Y/31/21/PL

Land East of Drove Lane Yapton BN18 0EB

Temporary sales cabin & associated landscaping. This application may affect the setting of listed buildings

Figure 2. Snippet of Proposed Site Layout

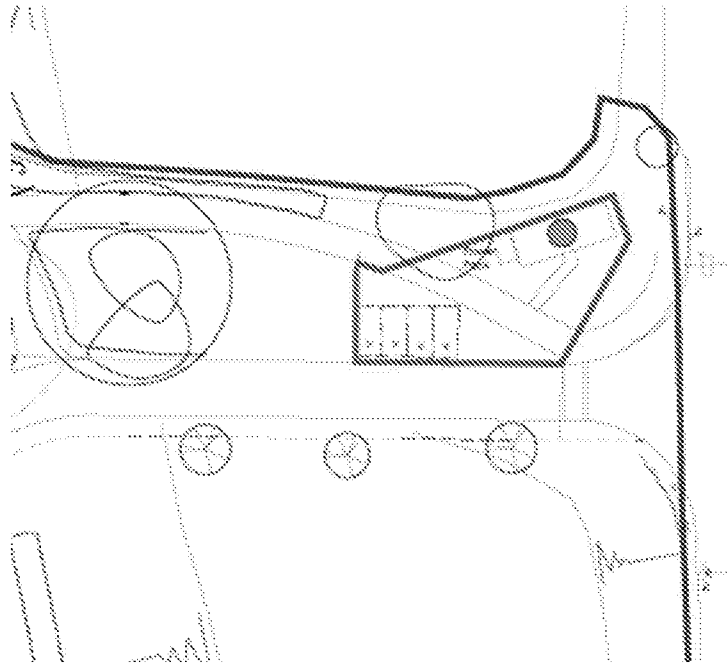
The proposed site plan indicates that the location of the temporary cabin is in an area that had previously been proposed to be landscaped and retained as part of the open space for the development. The refused reserved matters application indicated that the area covered by this application would be covered by existing/proposed vegetation. However, it would appear that the current application would require the existing to be removed.

The location would be clearly visible from Main Road along with the conservation area and other heritage assets. Whilst a scheme of landscaping has also been provided, which could help to soften its impact, it would have to be implemented as mature planting in order for it to have any significant positive impact.
